May 24, 2021

Re: Crossroads Mix Use Traffic Study Letter (PCD File No. P208 and SP2011)
SWC of Meadowbrook Parkway and Newt Drive
El Paso County, Colorado

CROSSROADS AT MEADOWBROOK MIXED USE PRELIMINARY PLAN

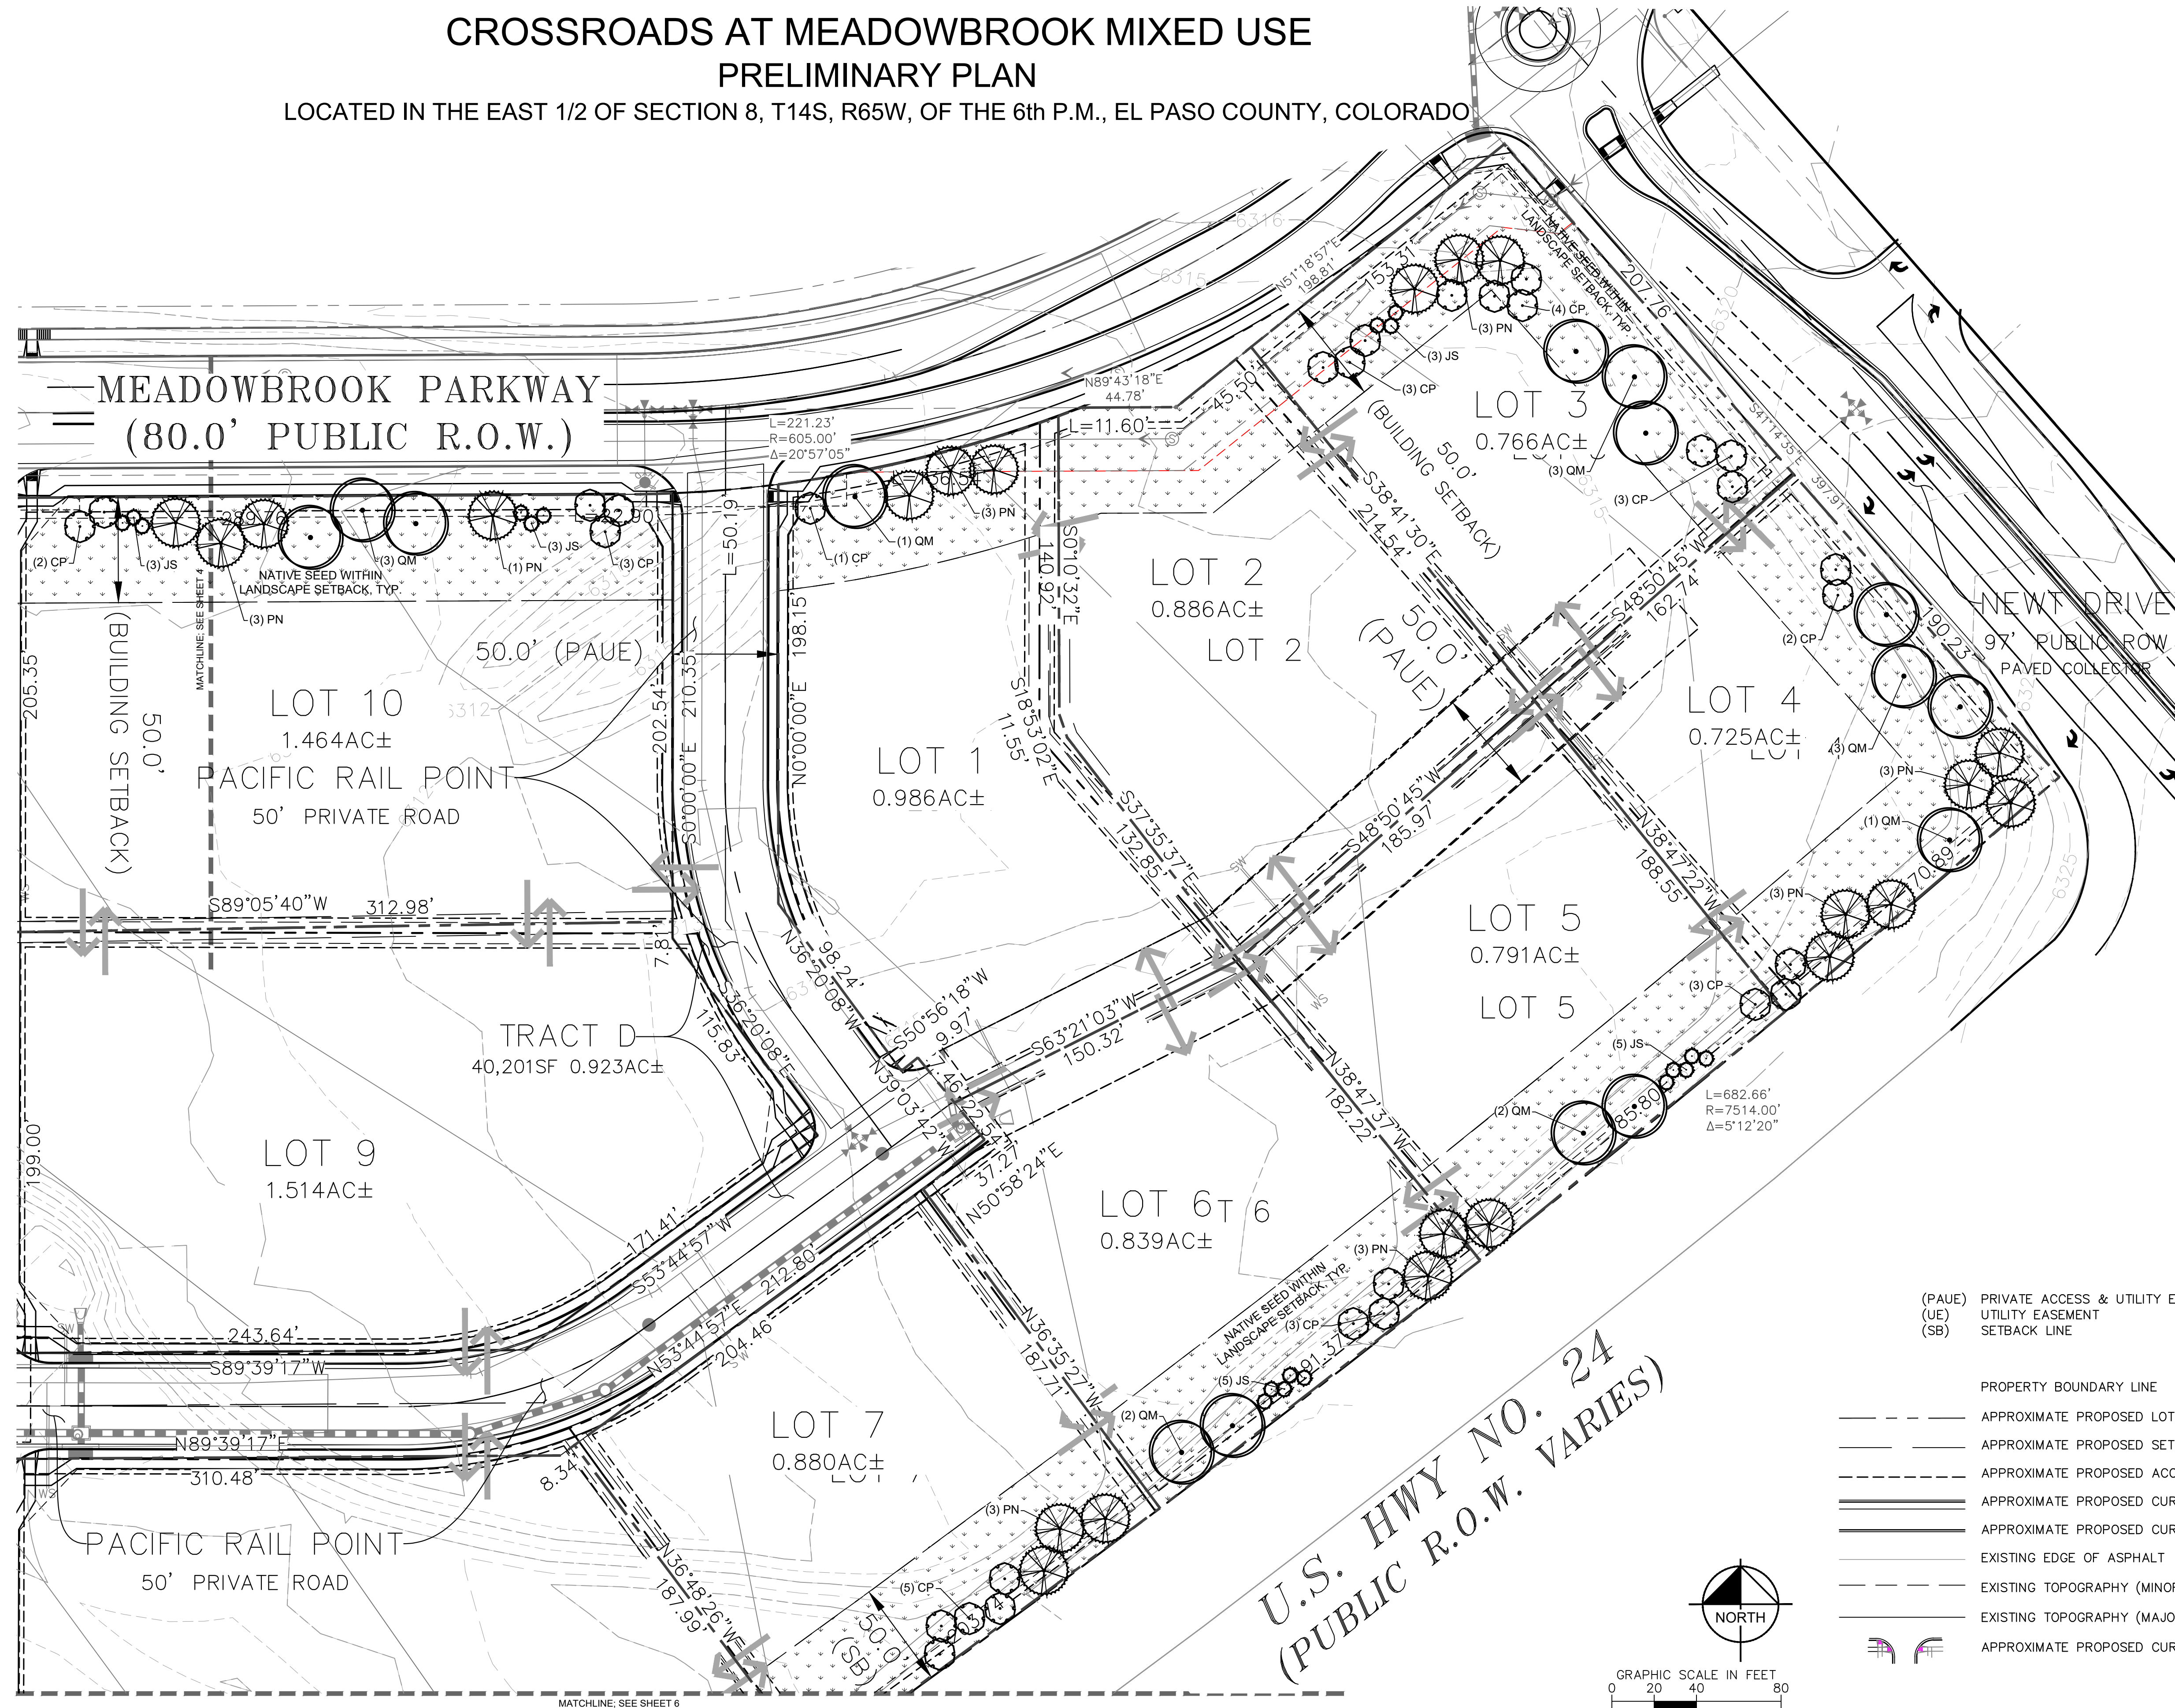
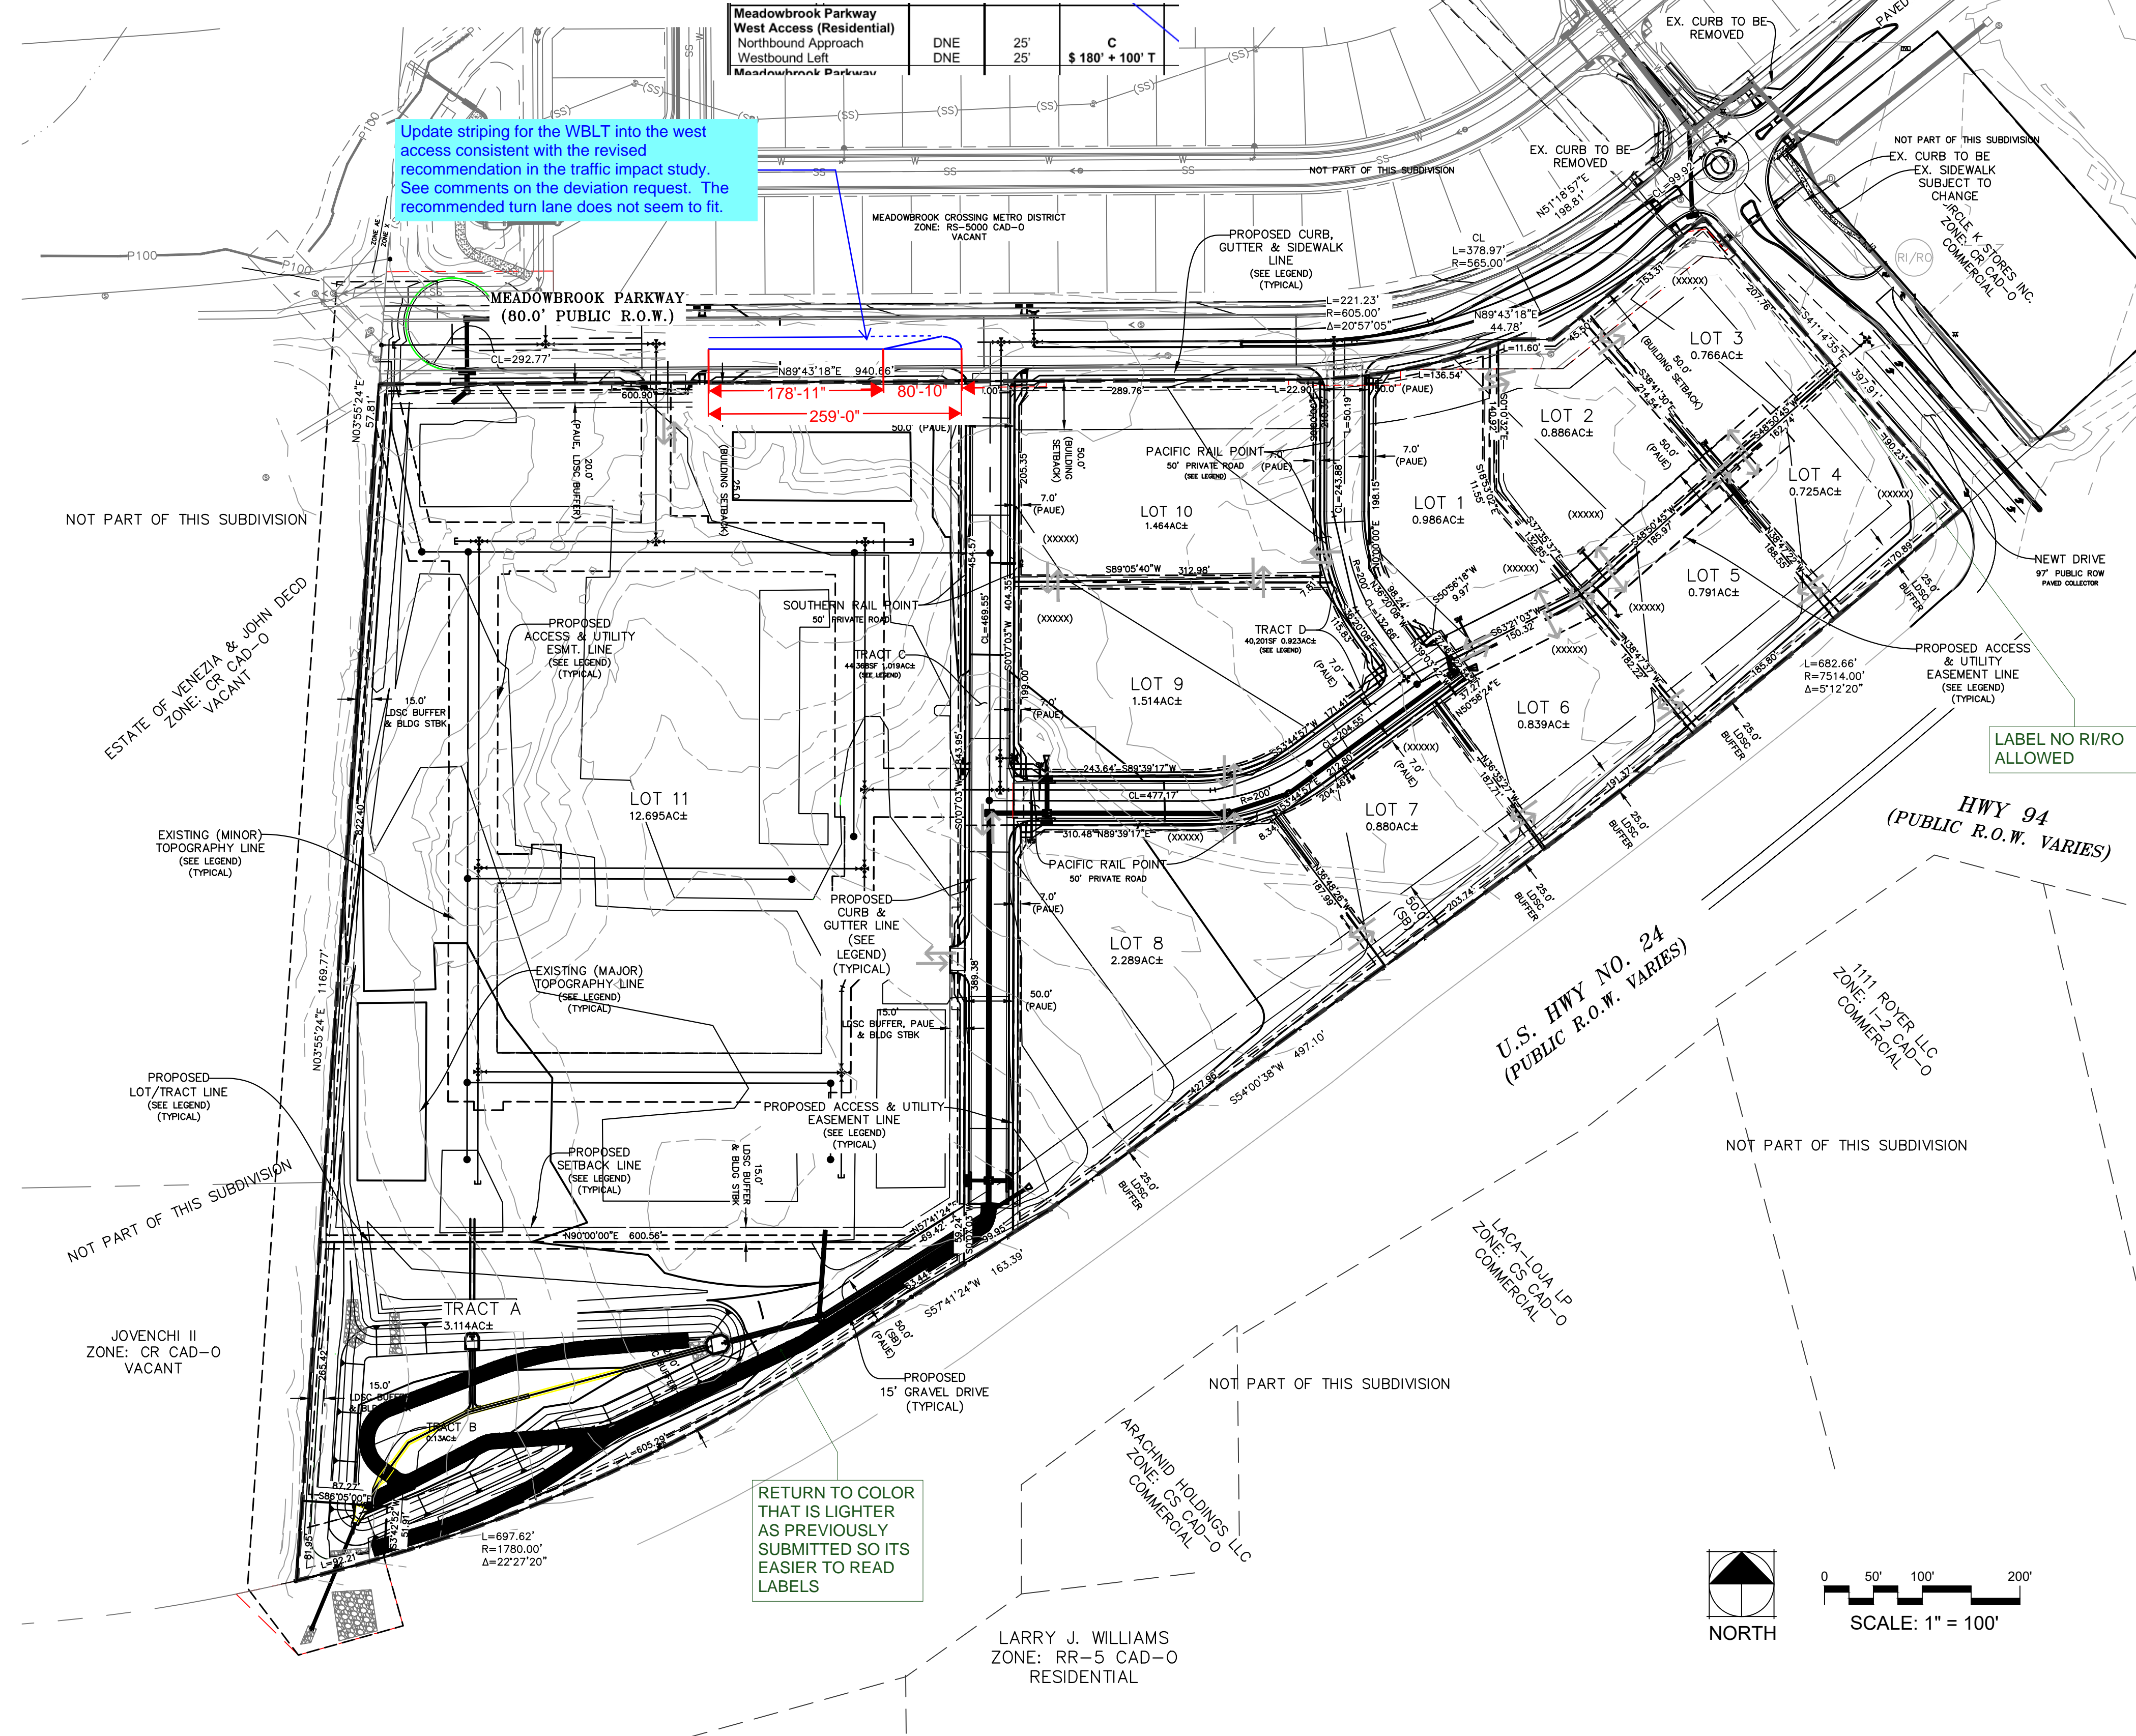
Update statement. The preliminary plan shows a raised median in front of the east access as a barrier against left turn movements

With the additional storage length double check that there is no conflict with the upstream intersection. Current intersection spacing does not have sufficient spacing to accommodate the required left turn lanes. Intersection spacings needs to be adjusted.

If the TIS is going to include this statement then provide a complete analysis of the feasibility of a full movement and the required WBLT lane length. Based on the layout there does not seem to be sufficient space for a WBLT that meets criteria. The middle access WBLT would be conflicting with this east access full movement and the roundabout splitter island

Per criteria this warrants exclusive left and right turn lanes. Revise the preliminary plan street layout to allow restriping for a second outgoing lane or submit deviation request for consideration.
